**Addendum No. 3**

RE: Contract # C204266

**Buncombe-Henderson Counties (I-4700)**

I-26 FROM NC-280 (EXIT 40) TO I-40

PROJECT REFERENCE NO.	SHEET NO.
1-4700	17
RW SHEET NO.	1-4700A-28
ROADWAY DESIGN ENGINEER	HYDRAULICS ENGINEER
DocuSigned by: Marc A. Whitmore 7/10/2019	DocuSigned by: John M. Blawie 7/10/2019
DOCUMENT NOT CONSIDERED FINAL UNLESS ALL SIGNATURES COMPLETED

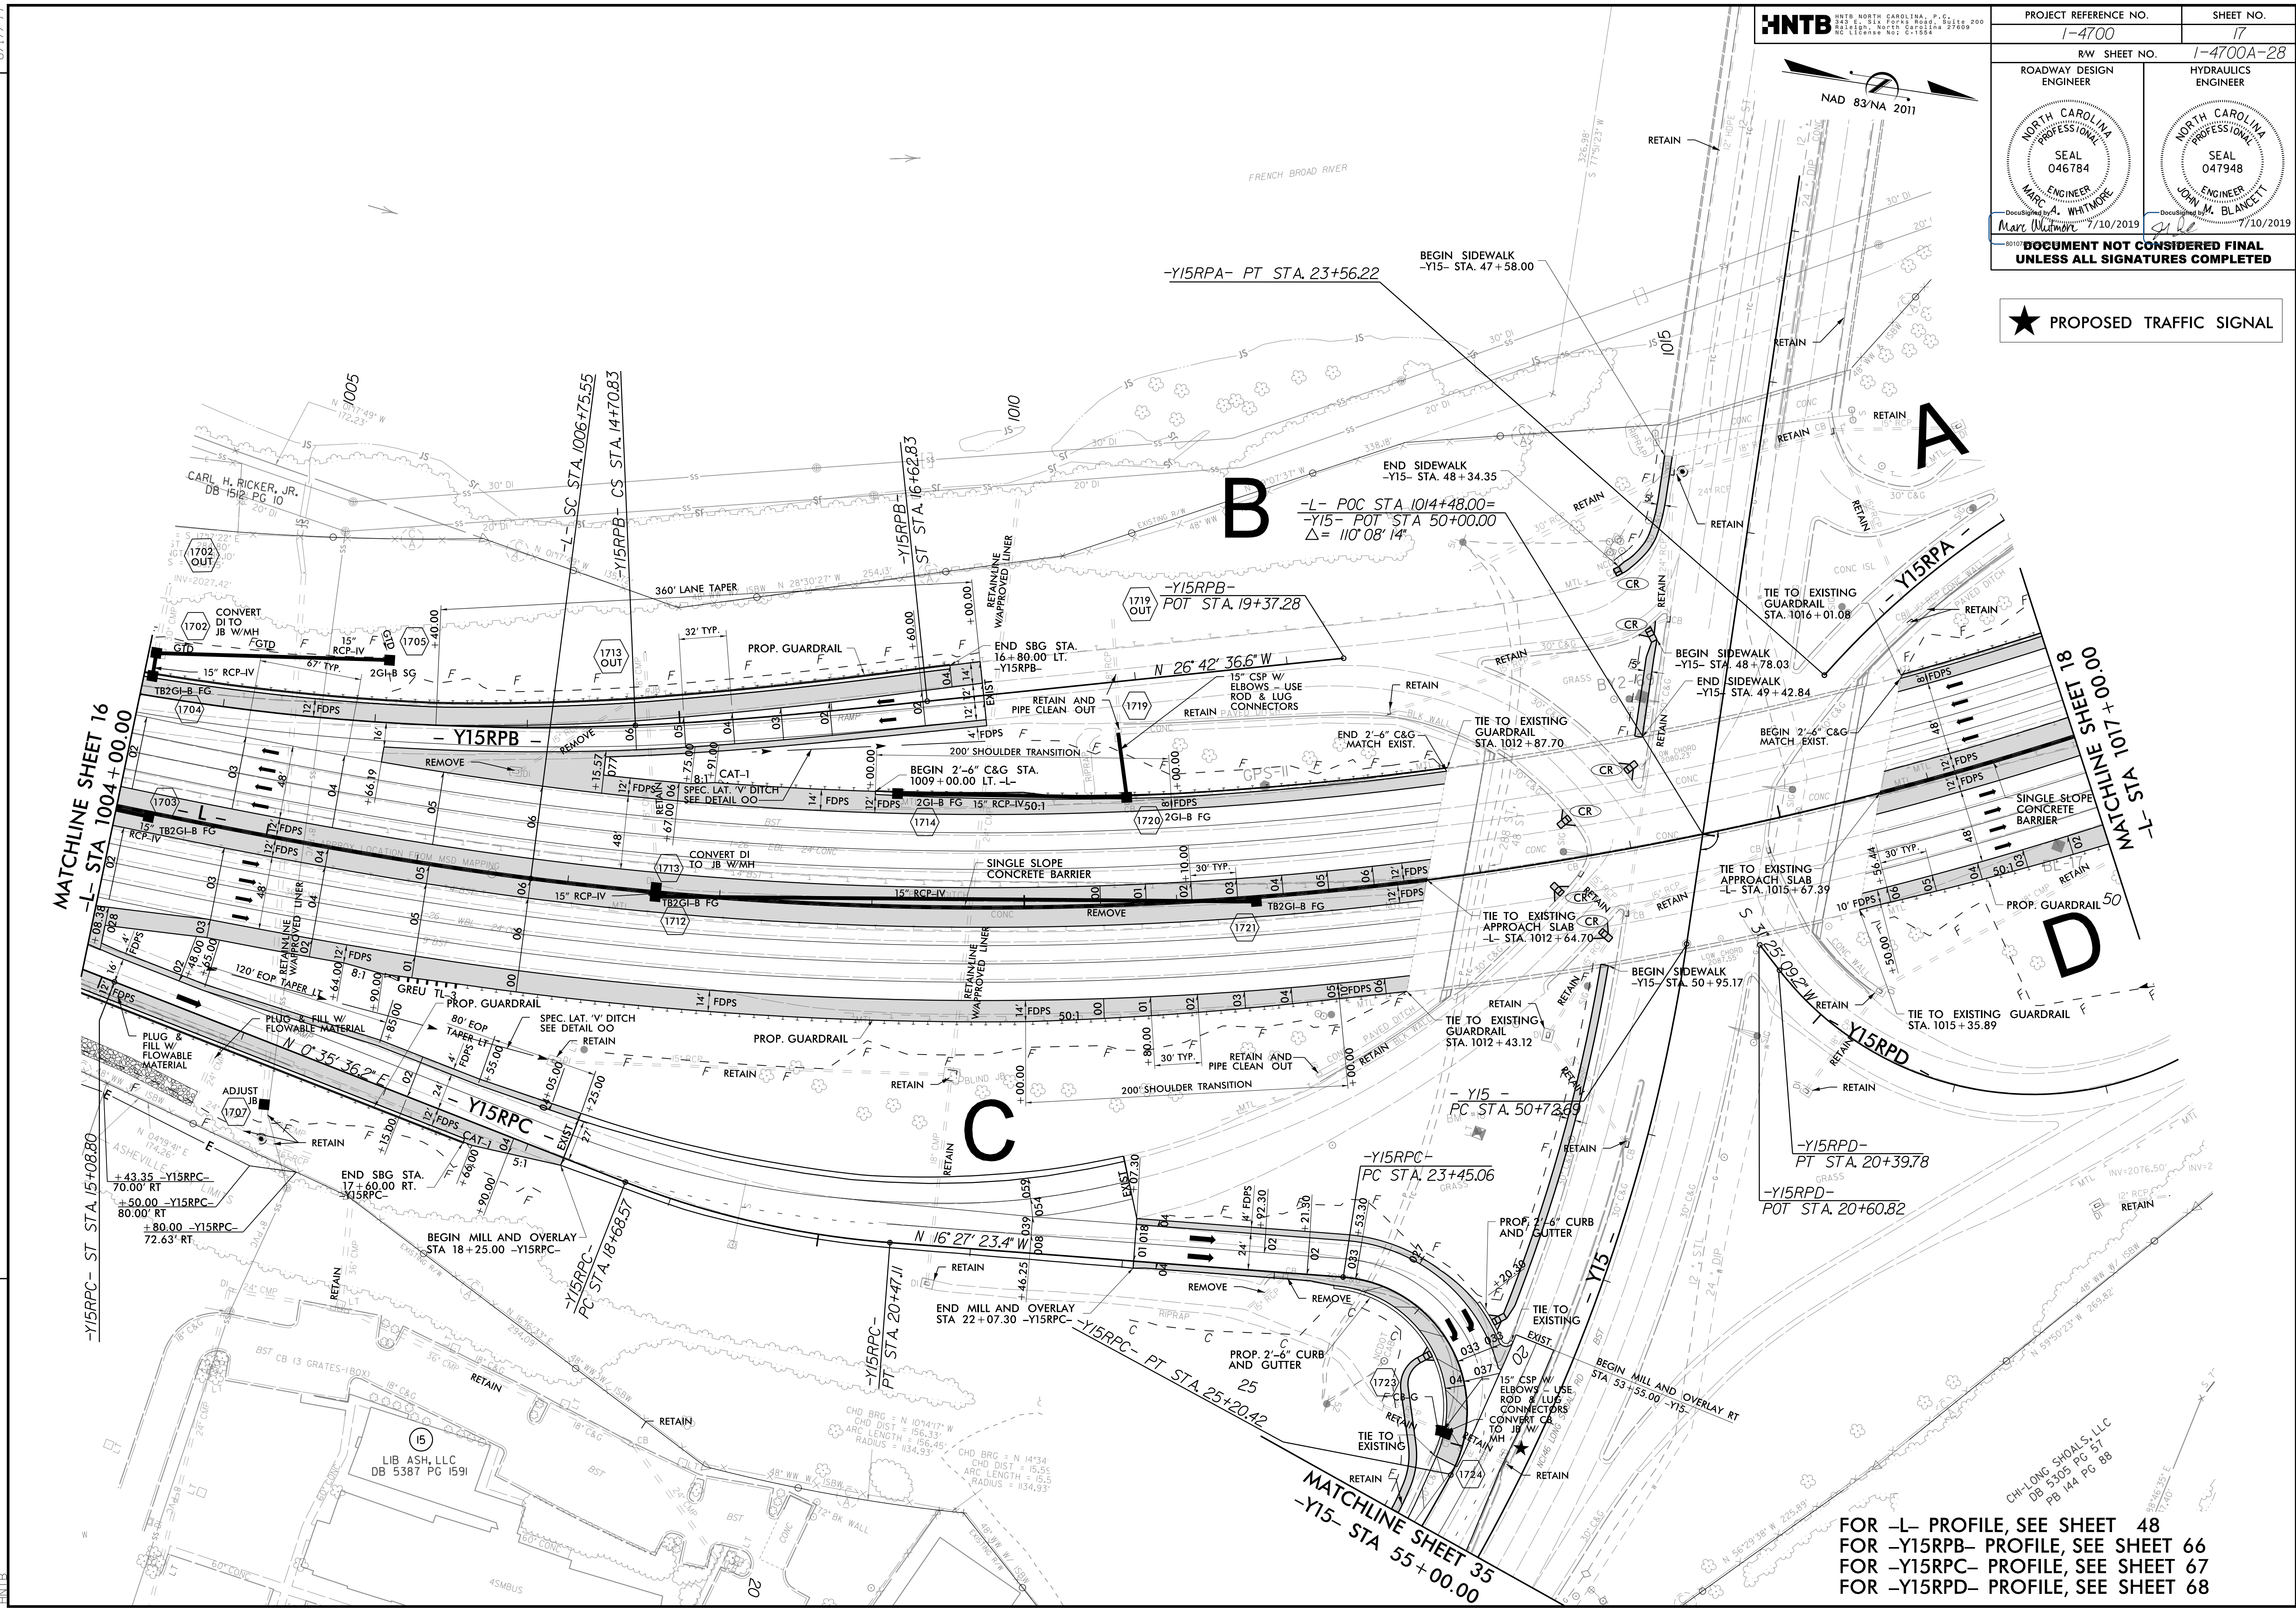
Sheet No.	Revision
3D-11, 3D-12, 3D-15, 3D-16, 3D-18, 3D-19, 3D-24, 3D-29, 3D-30	Revised Drainage Summary Sheets to reflect quantity changes shown below.
17	Revised to add note "Retain" to pipe
